STATE OF NORTH CAROLINA  
DEPARTMENT OF TRANSPORTATION

**Addendum No. 1**

RE: Contract ID: C201751  
WBS # 39995.3.GV1  
F. A. #IMS-95-1(73)0  
Robeson County (I-4914)  
I-95 from South Carolina State Line at MP-0  
to South of NC 711 at MP-16

**TYPICAL SECTION NO. 1**

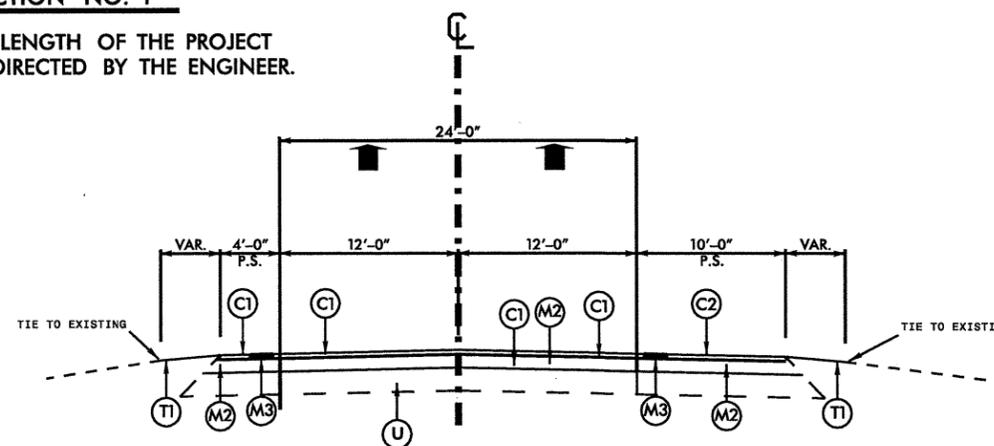
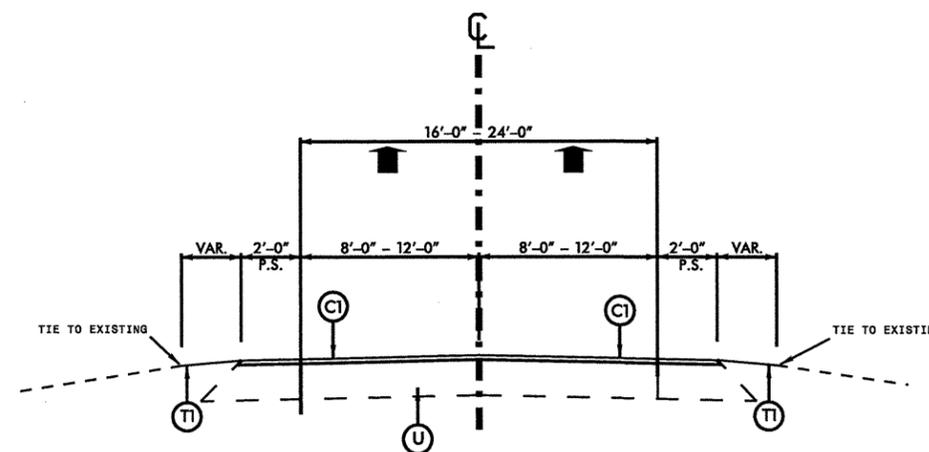
On Sheet No. 2, the typical sections have been revised to change the pavement type for the inside shoulder. Please void Sheet No. 2 and staple the revised Sheet No. 2 thereto.

PROJECT NO.	SHEET NO.	TOTAL NO.
39995.3.GV1	3	
I-4914

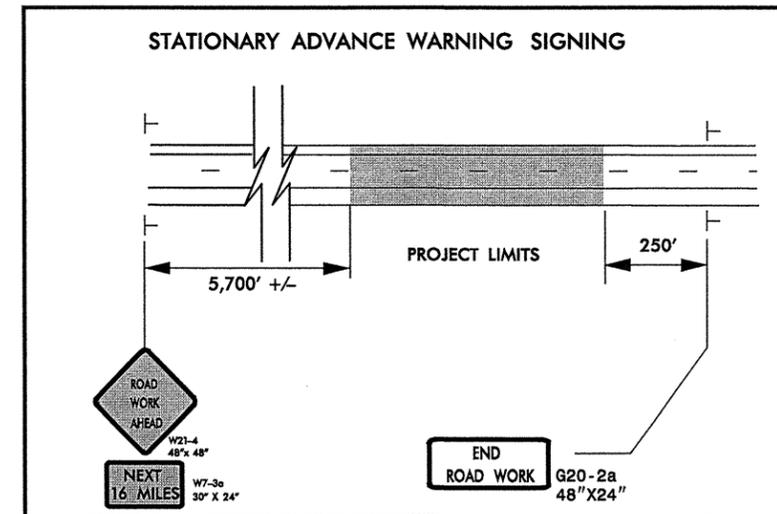
Sheet No. 3 has been revised to reflect the above mentioned changes. Please void Sheet No. 3 in your plans and staple the revised Sheet No. 3 thereto.
